East Hampshire District Council

Aquind Interconnector Project
Application for a Development Consent Order

Ref: EN020022

Response to Deadline Two

**Plate 5.7 – Converter Station – indicative elevations**

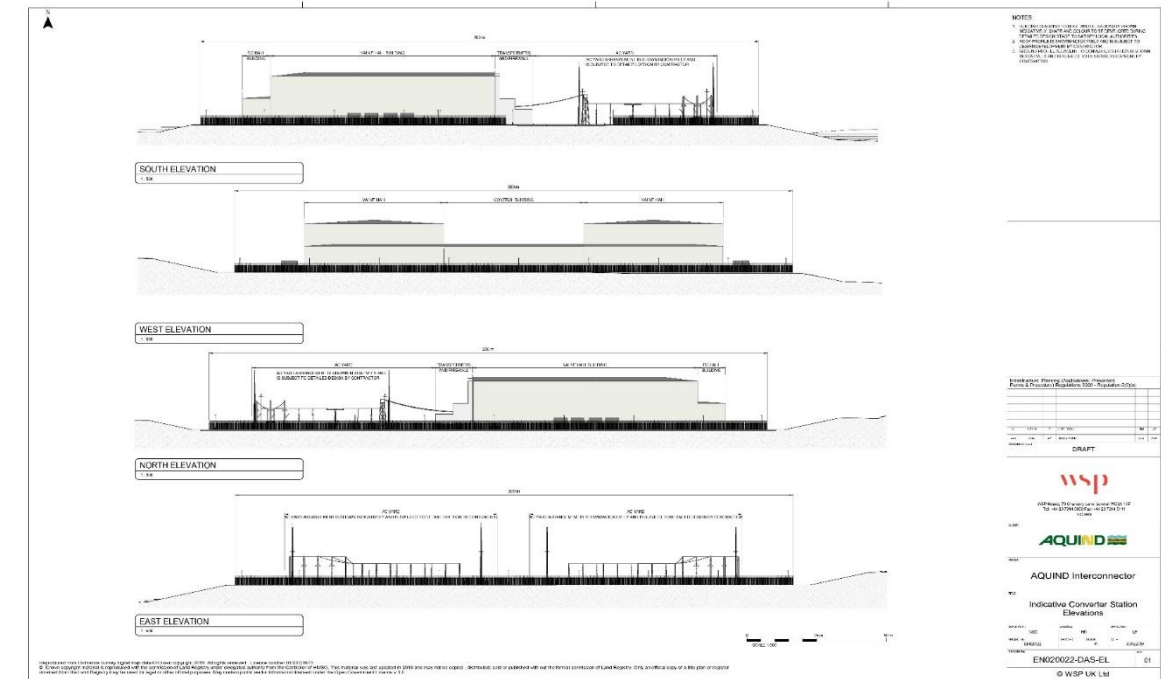
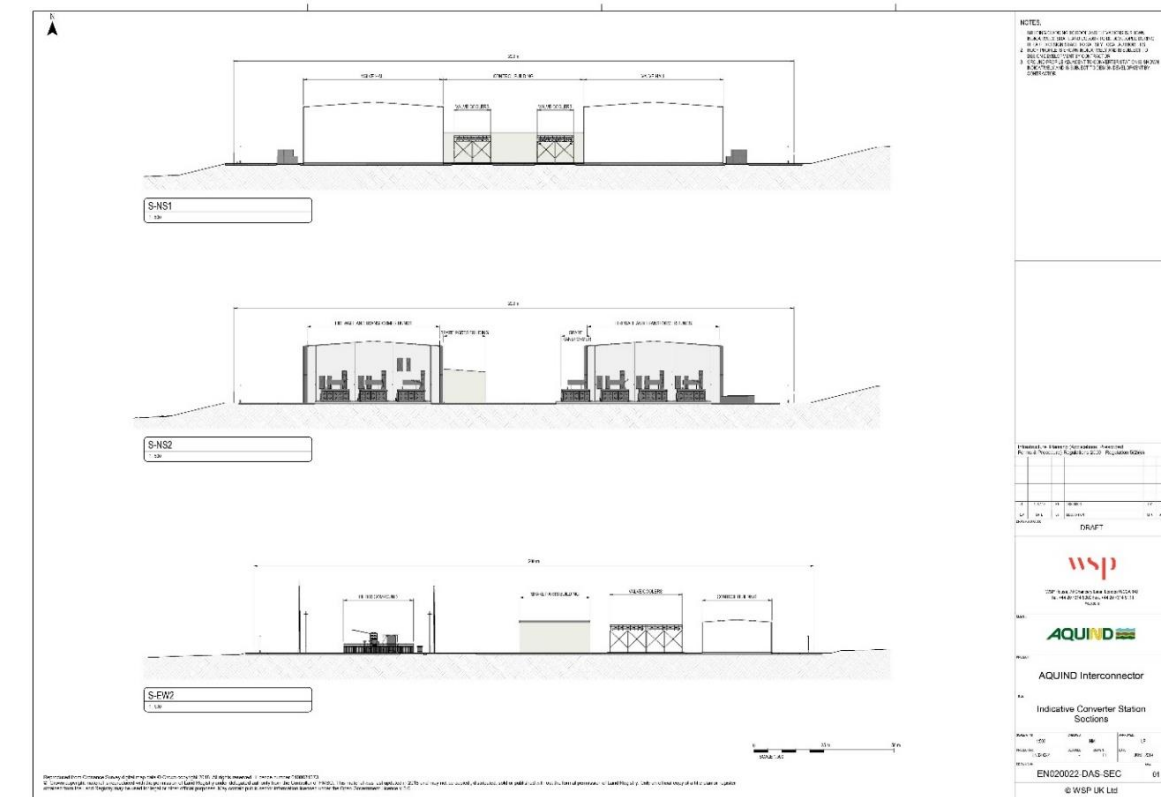
Section 5.2.4.3 states the standard roof design would result in a building height of 22m which has been the understanding throughout preliminary discussions. It is stated a more complex architectural solution may result in a building height of 26m which is a discernible difference and EHDC would like a landscape led approach to the scale of the building and a commitment to 22m rather than this being led by engineering / contractor preferences.

**Plate 7.8 Indicative elevation**

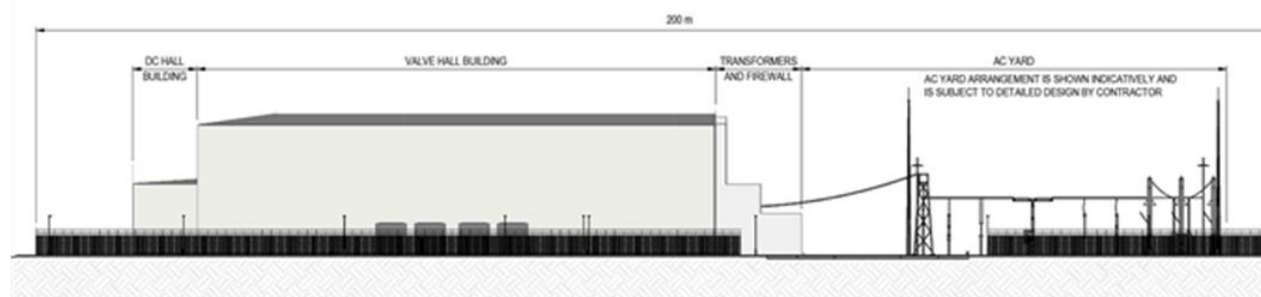
Section 5.2.3 provides more information on the AC switchyard. It is considered this will not greatly affect the landscape in view from the EHDC area other than the lightning masts, stated as being up to 30m in height. Reference is also made to the possibility of steel cables being strung between the masts, which would add to the appearance of visual clutter between the masts on the buildings and ground mounted masts.
